Rezoning Transportation Analysis

Petition Number: 2022-137

From: Jake Carpenter, PE

Date	Description
01-26-23	First Review (PDM)

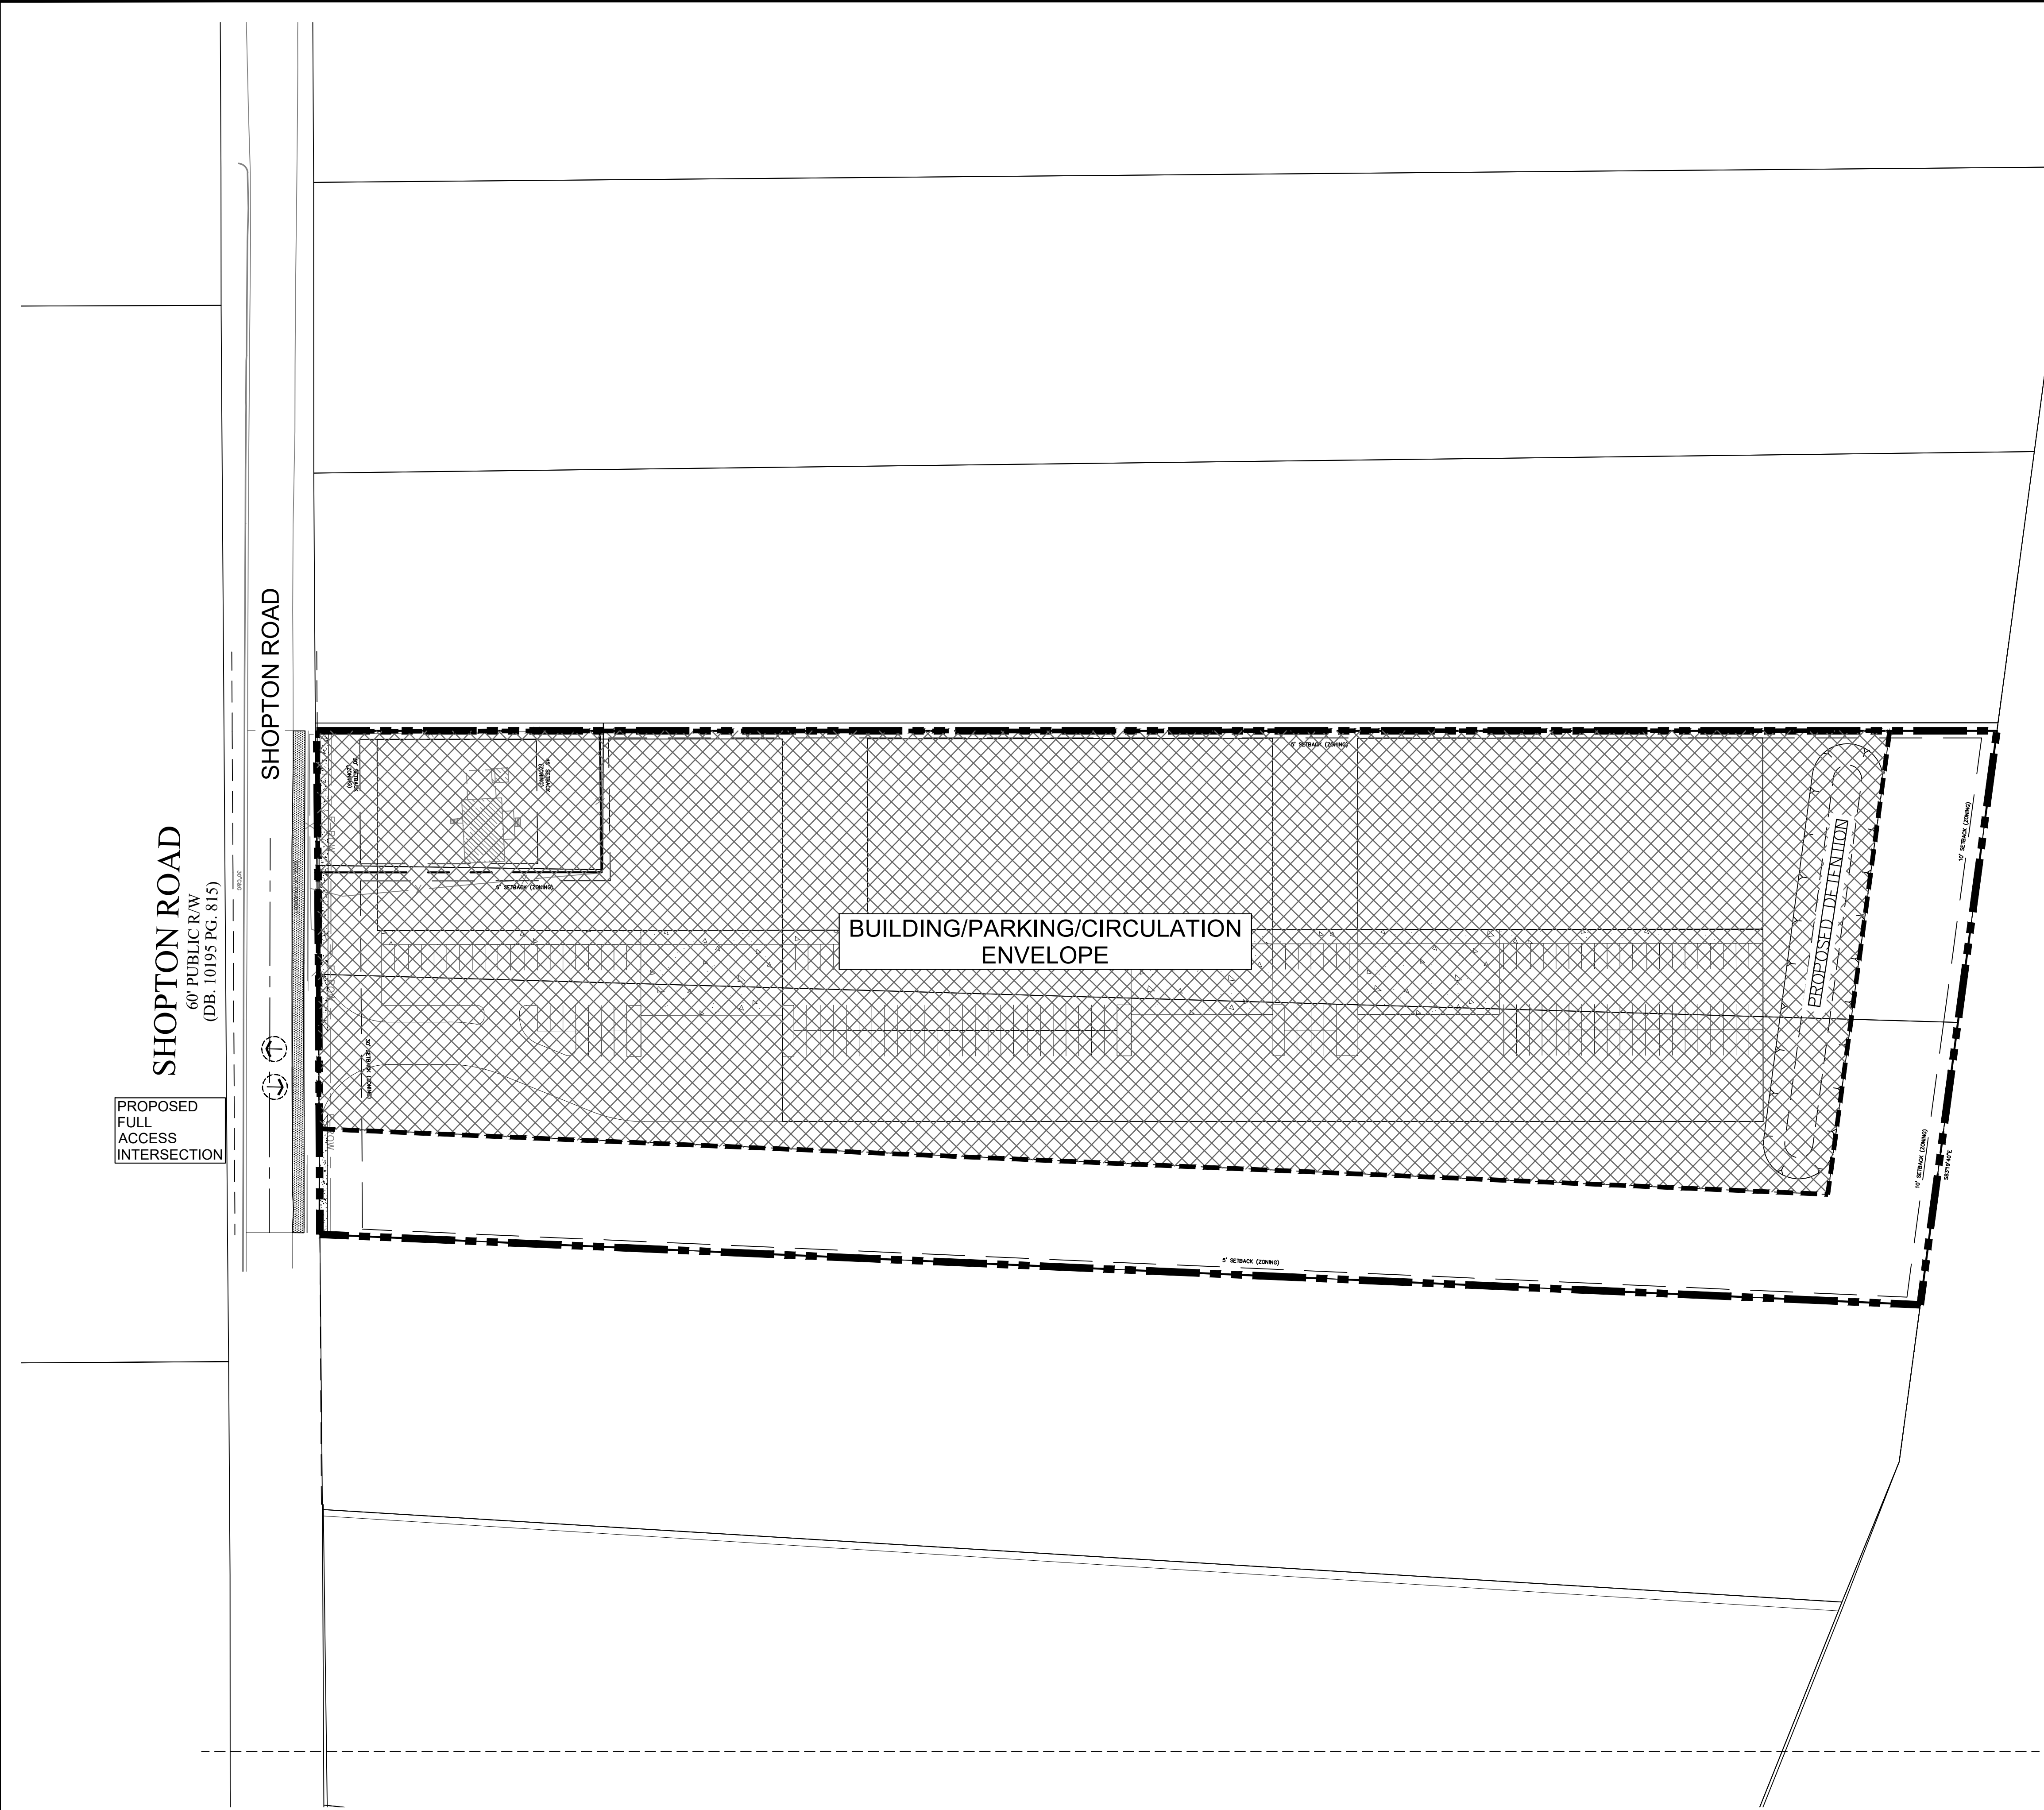
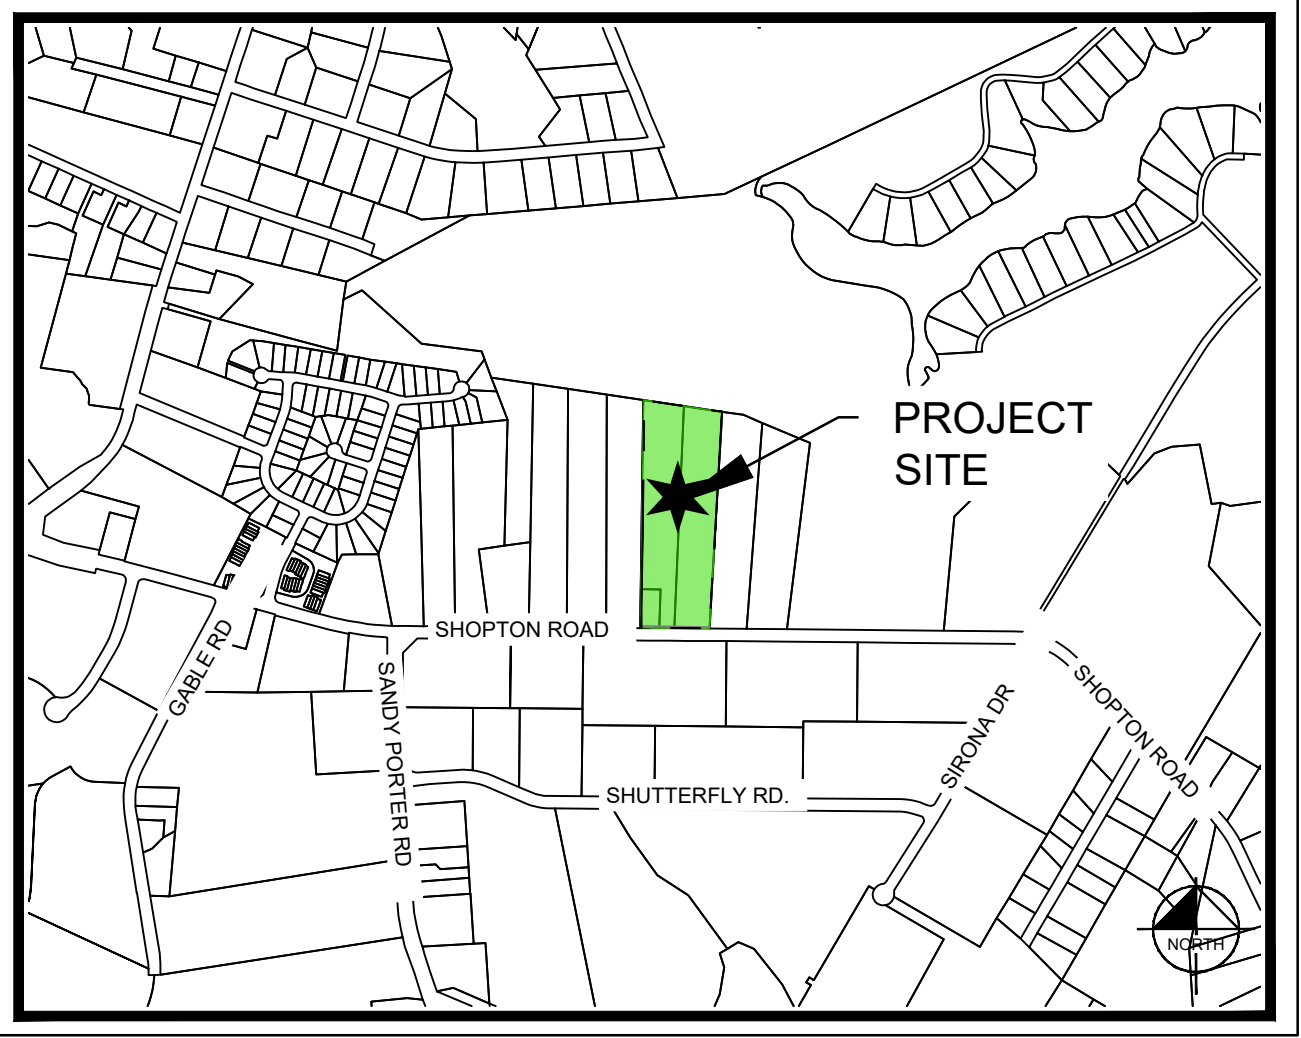
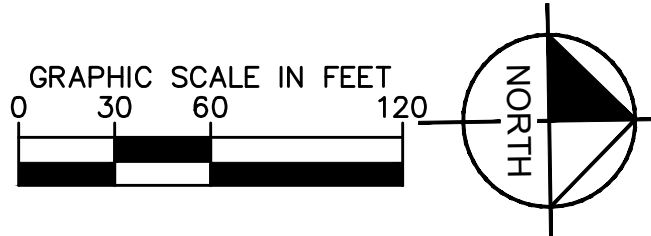
- a. **Shopton Road:** Location of curb and gutter to be moved to 27 feet from roadway centerline to accommodate the Charlotte Streets Map with a roadway typical section of a two plus lane avenue with buffered bike lanes.

Label and dimension the curb and gutter from the centerline for each road on the site plan.

3. Per coordination with NCDOT, restripe the existing median on Shopton Road from Sandy Porter Road to the proposed site access to a two way left turn lane. The site plan should be revised to show the roadway laneage.

4. Per coordination with NCDOT provide and dimension a 100-foot minimum protected driveway stem dimensioned from the ROW.
5. Revise site plan and conditional note(s) to commit to construct an 8-foot planting strip, and 8-foot sidewalk on Shopton Road per Chapter 19. The site plan shall label and dimension both items from the back of curb and gutter or edge of pavement. The wider sidewalk also meets the Charlotte WALKS Policy.

6. Site is to remain in the ETJ: Revise site plan and conditional note(s) to construct 8-foot planting strips and 8-foot sidewalks on Shopton Road. The site plan shall label and dimension both items from the back of curb and gutter or edge of pavement. Add conditional note: The entire facility must be outside of the right of way and within a public access easement. Add conditional note committing to construction and maintenance of the 8-foot sidewalk on Shopton Road.

7. Revise site plan and conditional note(s) to commit to construct bicycle facilities by locating the curb and gutter 27' from the center line to meet the Council-adopted Charlotte BIKES Policy.
